CITY OF ALBUQUERQUE

July 12, 2021

Re: **ASI**
4500 Paseo Del Norte NE
Traffic Circulation Layout
Architect's Stamp 07-07-2021 (D17-D110)

Sheet: Enlarged Ramp / Stair Details

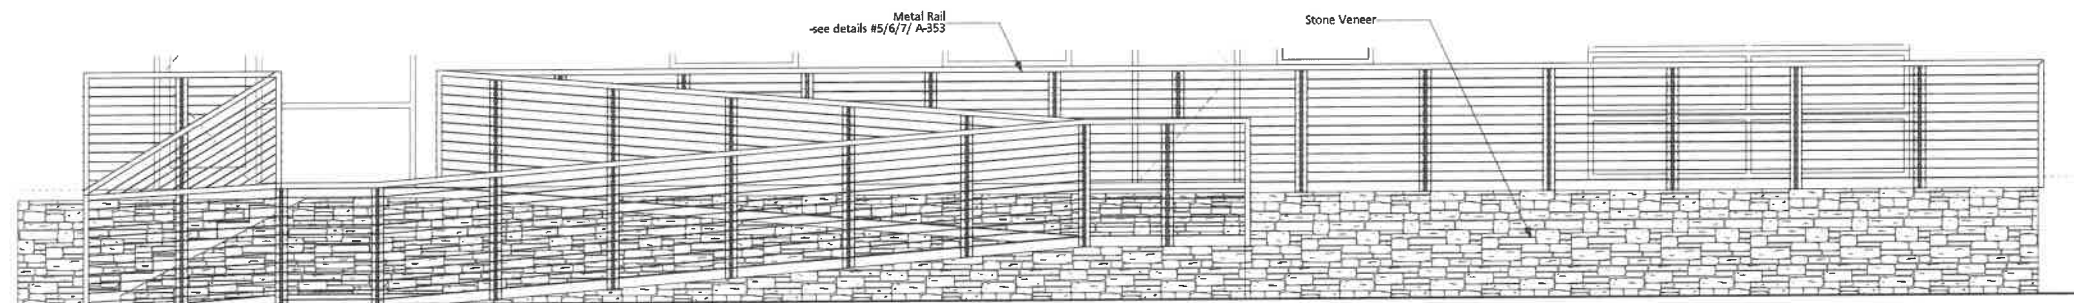
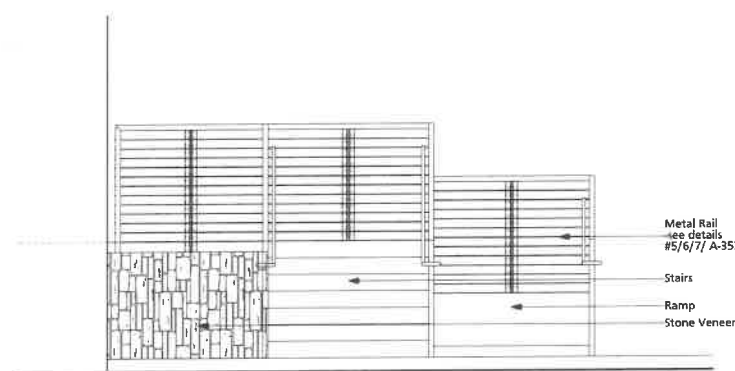
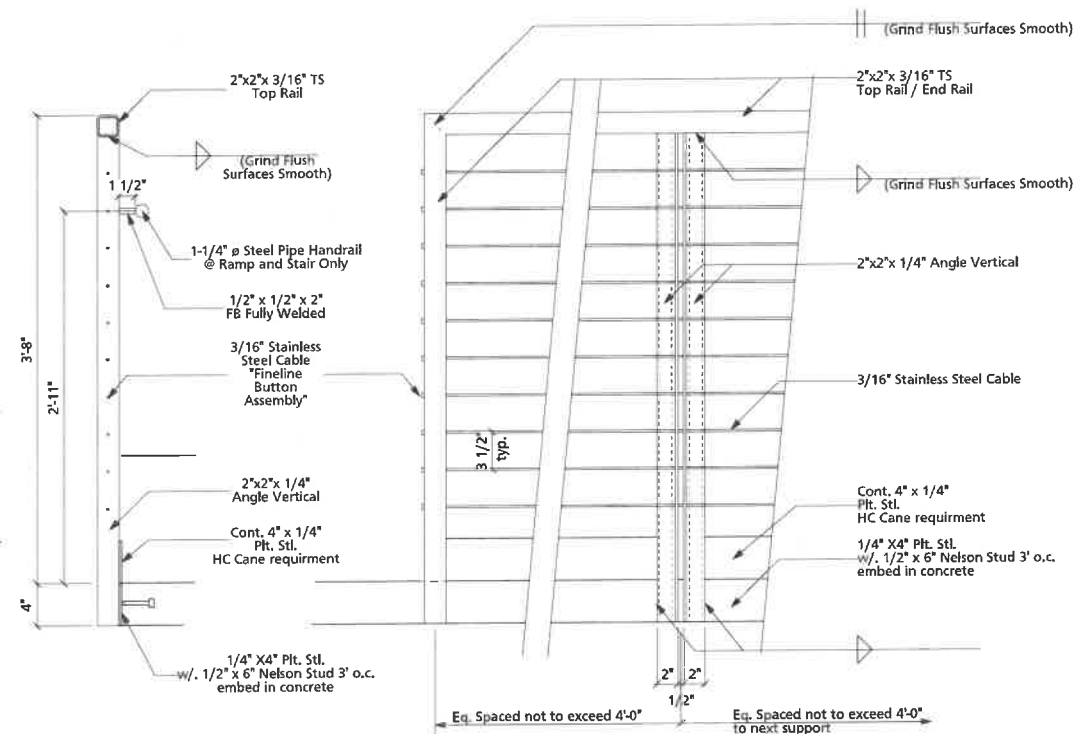
15. Per DPM, a 6 ft. wide ADA accessible pedestrian pathway is required from the ADA parking stall access aisles to the building entrances. Please clearly show this pathway and provide details (**Details to include ADA ramp and possibly handrails: also provide dimensions and slopes**).

Sheet: Traffic Control Layout

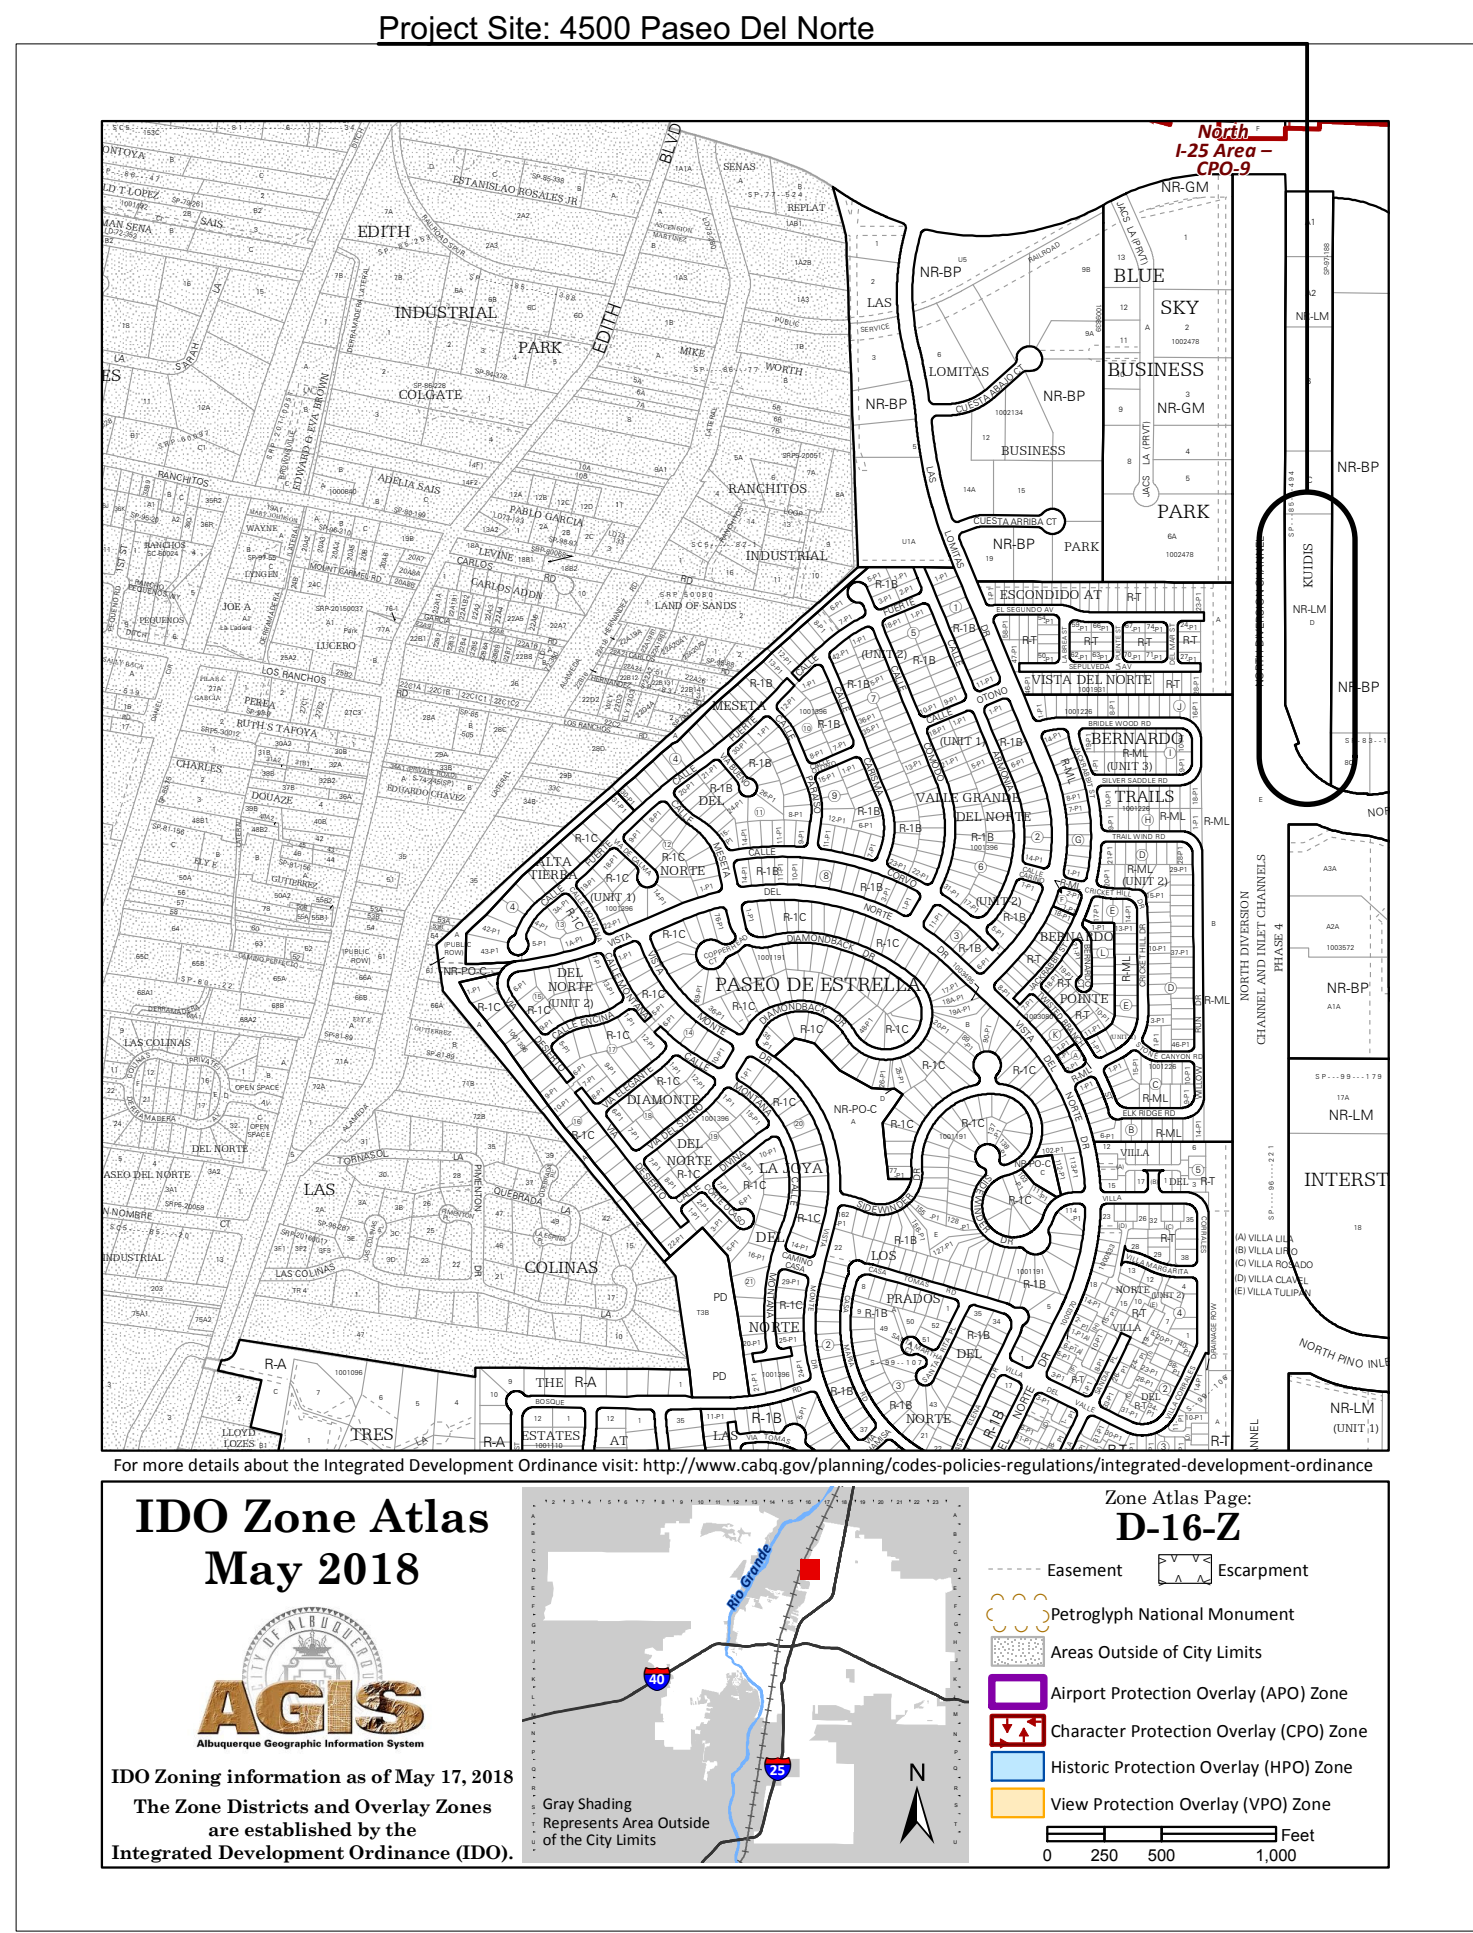
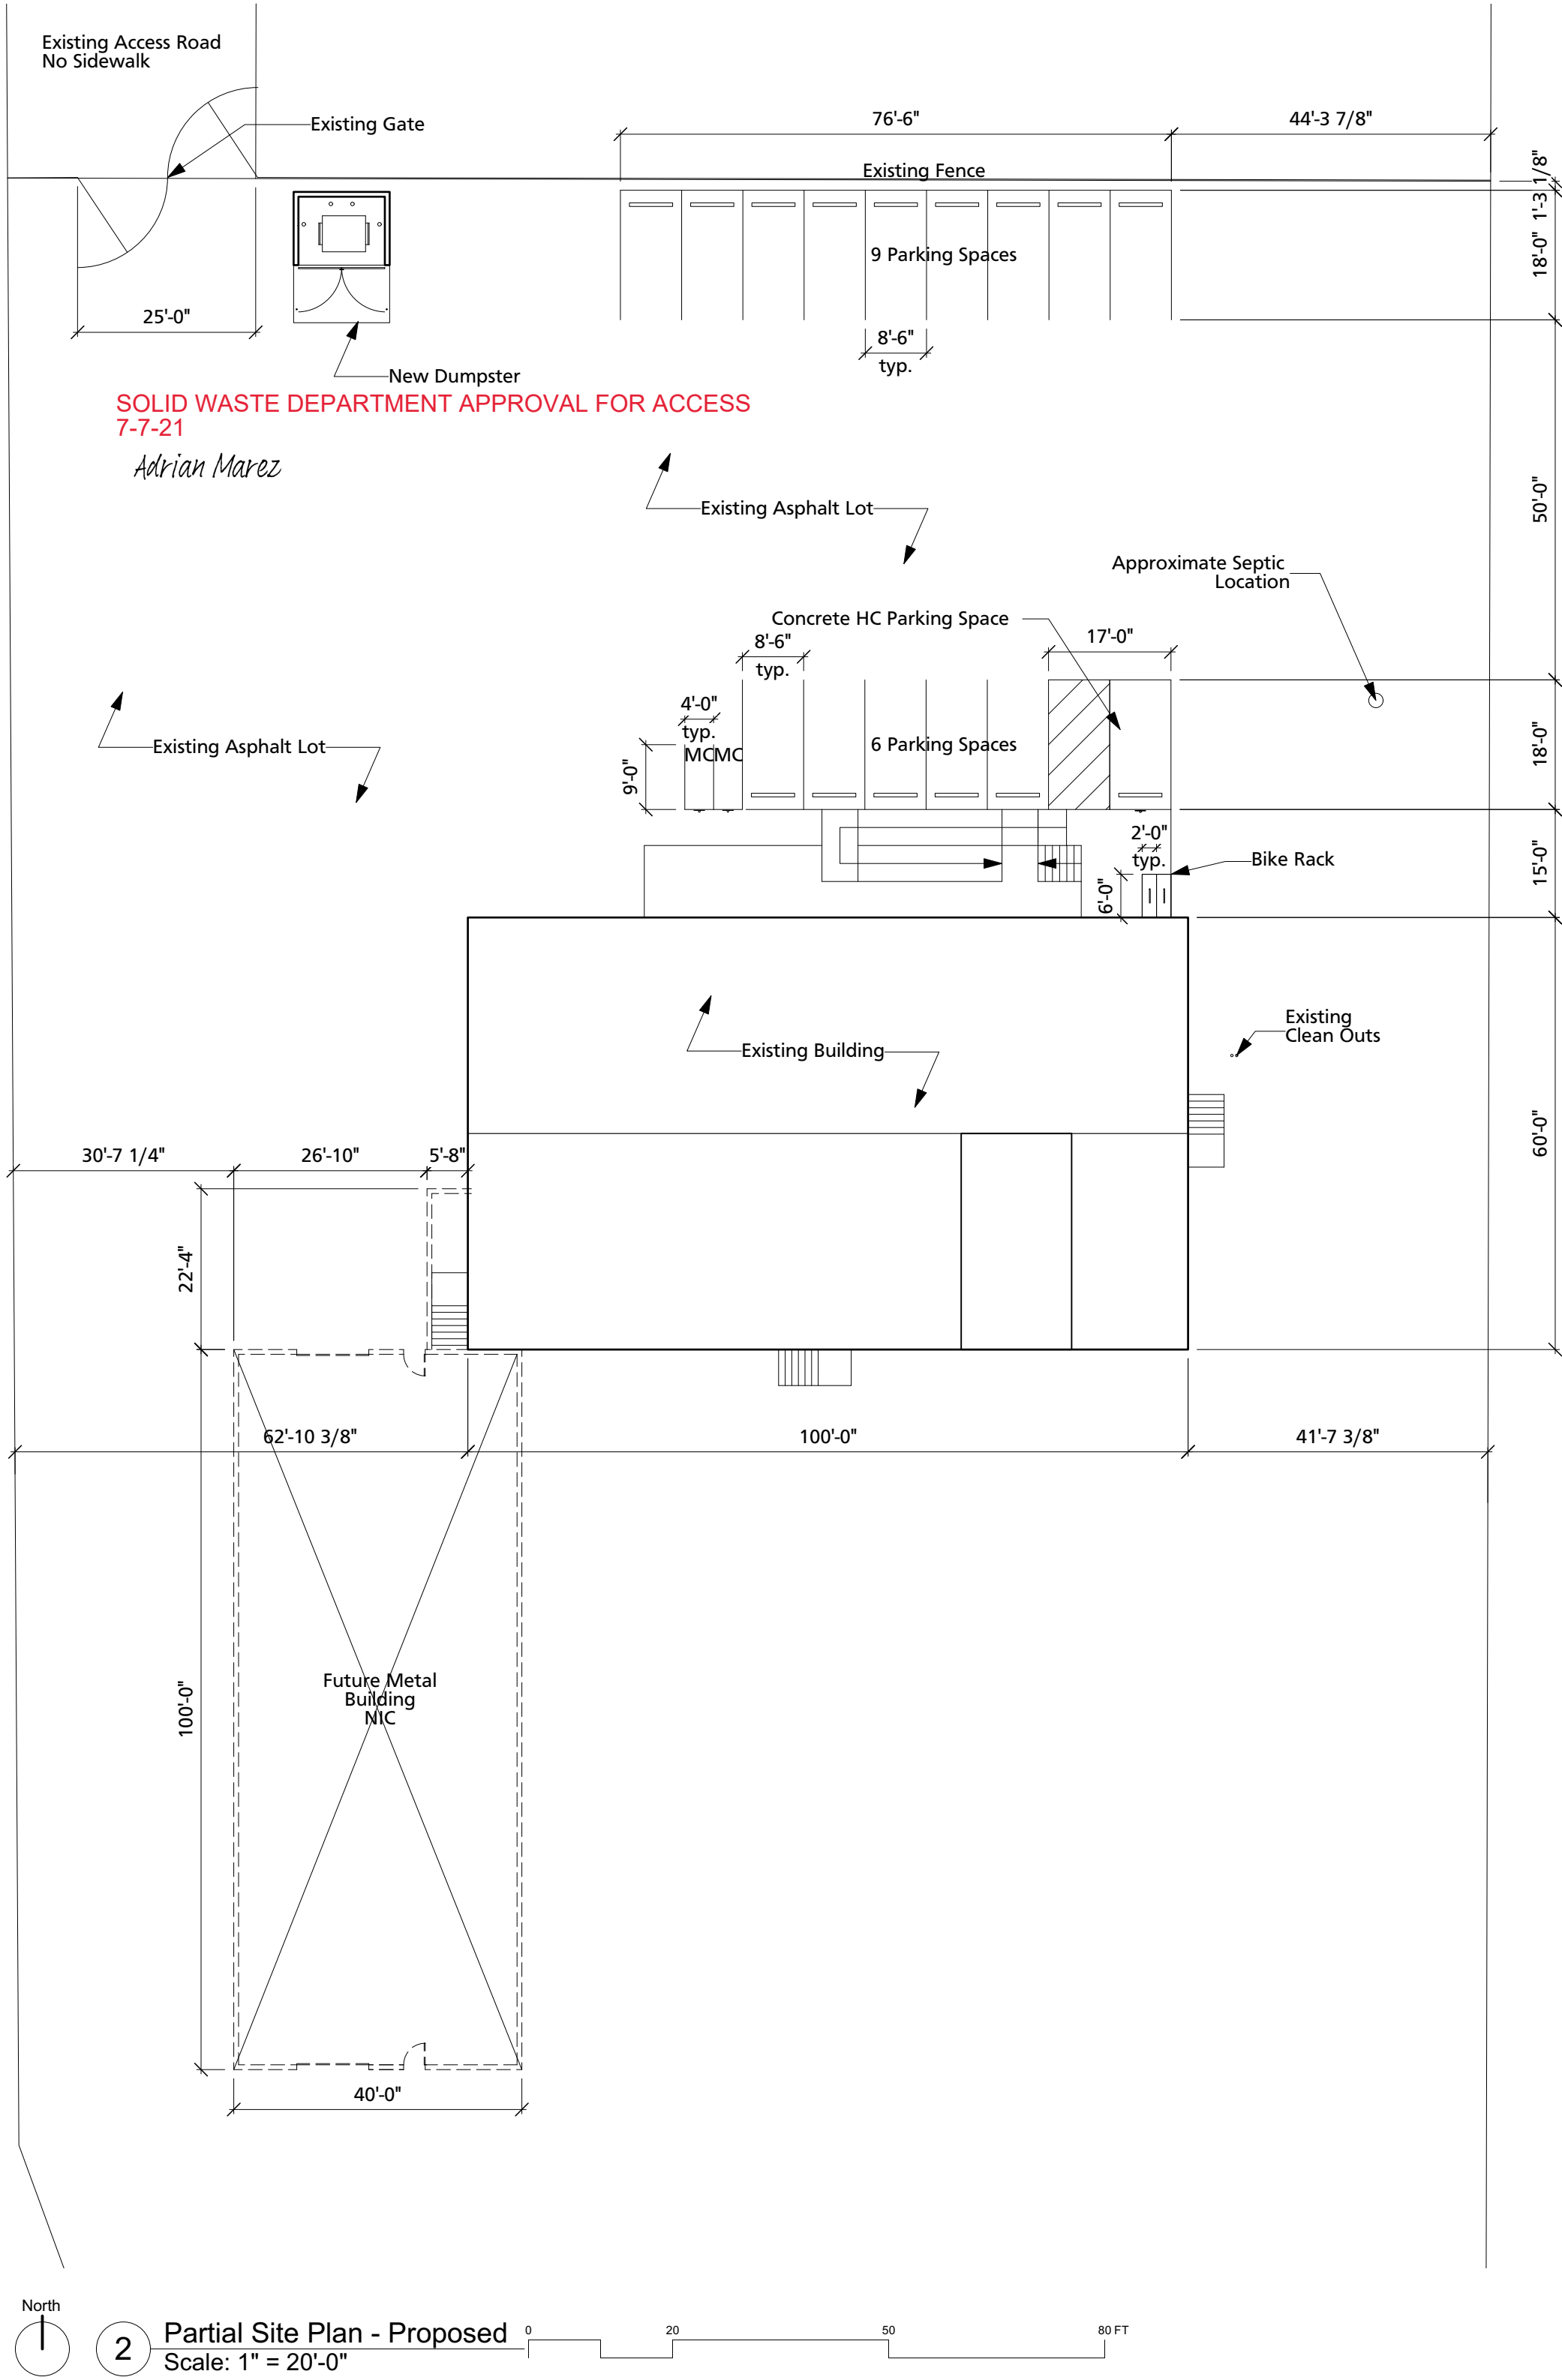
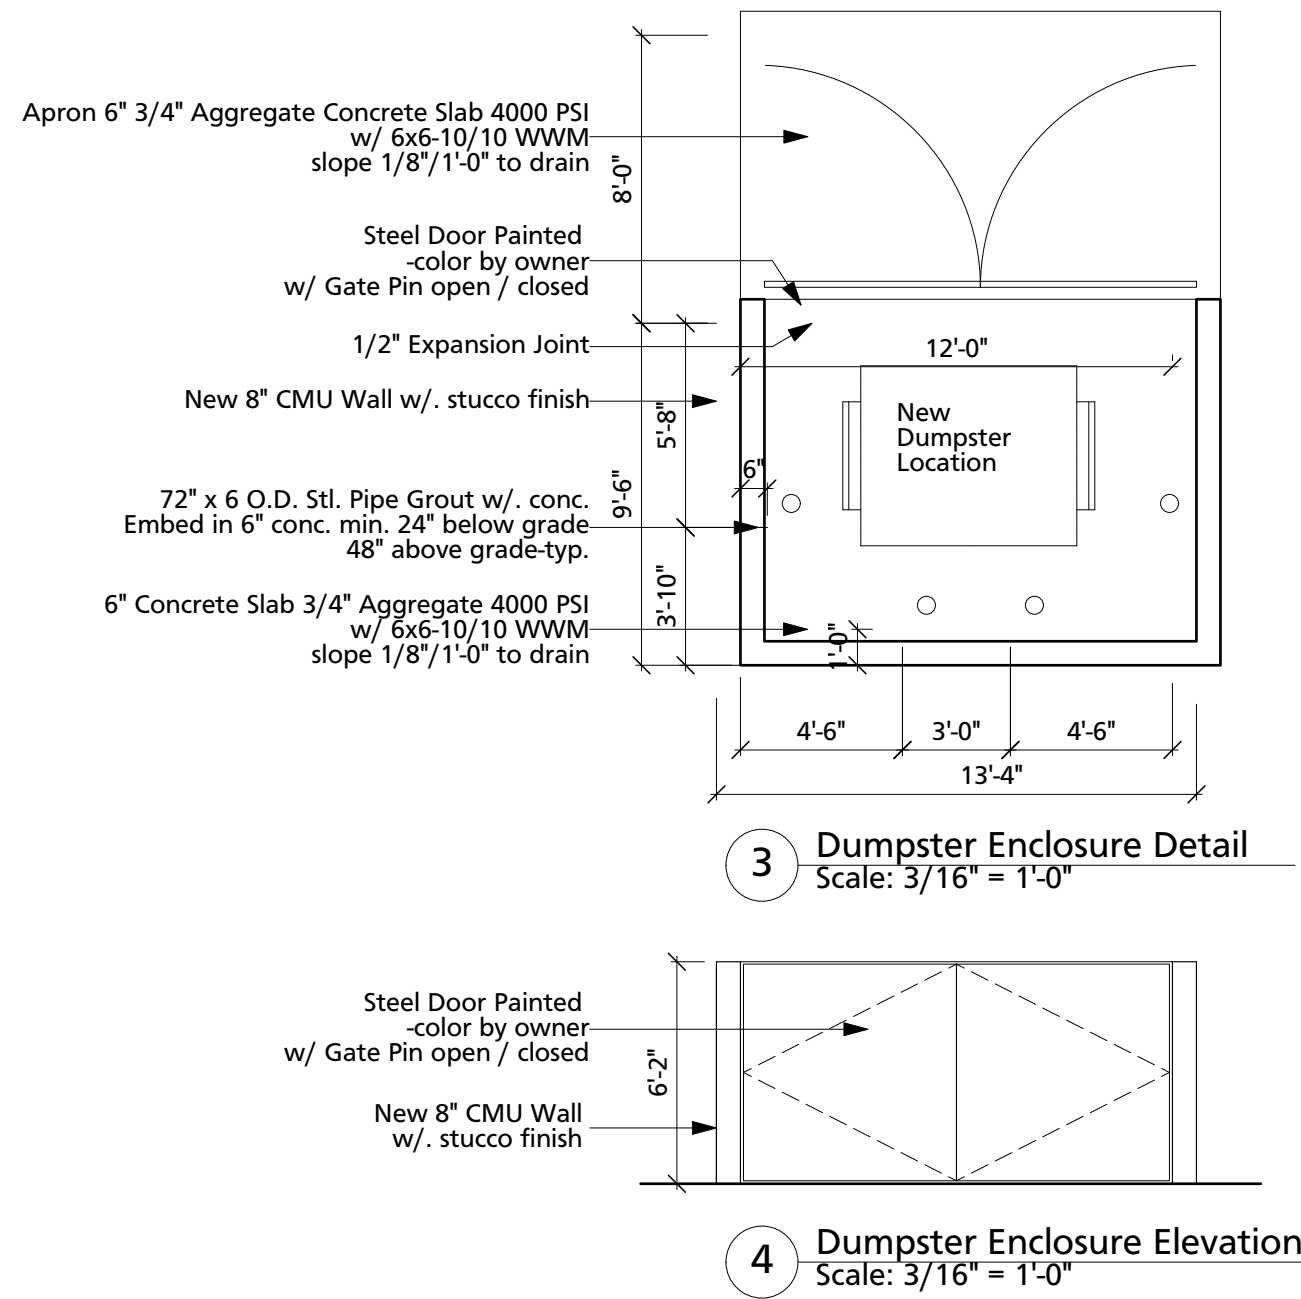
1. Please **List the number of parking spaces required by the IDO** as well as the proposed number of parking spaces including **bicycle and motorcycle parking** and **coordinate/discuss with Zoning**.
2. **Access Road:** Provide the existing roadway and ROW widths.
3. **Review DPM** for the private **access roadway width** and **sidewalk requirements**.
4. Identify all existing **access easements and rights of way width dimensions**.

6. The ADA accessible spaces must include an access aisle. Van accessible aisles should be **8ft wide**; all others should be 5ft wide.
7. The ADA accessible parking sign must have the required language per 66-7-352.4C NMSA 1978 **"Violators Are Subject to a Fine and/or Towing."** Please call out detail and location of signs.
8. The ADA access aisles shall have the words **"NO PARKING"** in capital letters, each of which shall be at least one foot high and at least two inches wide, placed at the rear of the parking space so as to be close to where an adjacent vehicle's rear tire would be placed. (66-1-4.1.B NMSA 1978)

9. **Motorcycle parking spaces shall be designated by its own conspicuously posted upright sign, either free-standing or wall mounted per the zoning code.**

10. **All bicycle racks shall be designed according to the following guidelines:**
 - a. **The rack shall be a minimum 30 inches tall and 18 inches wide.**

12. **A 1-foot clear zone around the bicycle parking stall shall be provided.**
13. **Bicycle parking spaces shall be at least 6 feet long and 2 feet wide.**

14. Per the IDO, a 6 ft. wide ADA accessible pedestrian pathway is required from the public sidewalk to the building entrances. Please clearly show this pathway and provide details.**If applicable and if sidewalk requirements mandate or not.**

18. **Provide a copy of refuse approval.**
19. **Detail for parking bumpers/barriers need to be provided.**
20. Please provide a sight distance exhibit **(If applicable)**

21. Show the clear sight triangle and add the following note to the plan: "Landscaping and signage will not interfere with clear sight requirements. Therefore, signs, walls, trees, and shrubbery between 3 and 8 feet tall (as measured from the gutter pan) will not be acceptable in the clear sight triangle **(If applicable)**."
